Appeal Decision

Appeal Ref: APP/R4408/D/18/3207807

15 Darton Hall Drive, Darton, Barnsley, S75 5AG

SITE PLAN

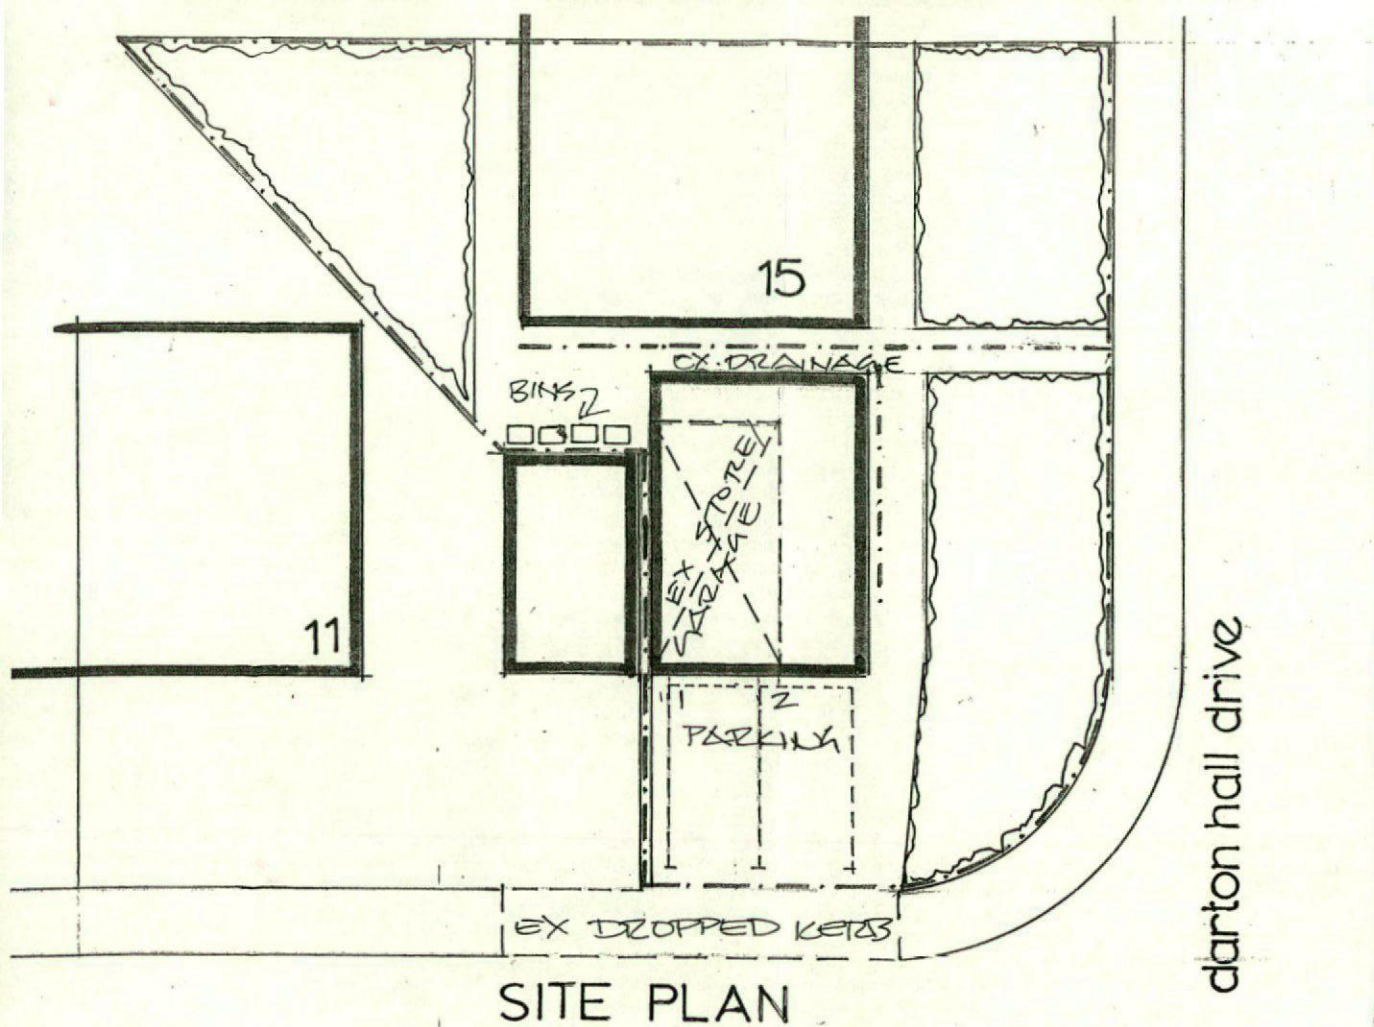
4. The proposed development would involve the demolition of the existing detached garage and the erection in its place, and on a larger footprint, of a detached granny annexe. The annexe would be around 8 metres deep and 5.8 metres wide with a hipped roof at its southern end and a gable end to the north, facing the side elevation of the bungalow. It would be some 2.4 metres high to the eaves and 4.4 metres high to the roof ridge.

8. In this case, the small garage at the appeal property would be replaced with a much larger building that would have a footprint over twice the size, and that would be around twice the existing height to ridge level. Moreover, it would appear that the annexe would have a footprint around 70% the size of the existing main dwelling. For this reason, I consider that the proposed annexe would be of such a scale and location that it would be a discordant feature on this prominent corner plot, and that it would be harmful to the character and appearance of the area. It would not appear subservient to the existing dwelling and would be out of context with its surroundings.

9. On the basis of the above, the proposed annexe would fail to comply with the provisions of Policy CSP29 which requires that development should contribute towards creating an attractive neighbourhood. Furthermore, whilst accepting the limitations of the site, it would not be sited in the rear garden and therefore conflicts with the requirements of the SPD.
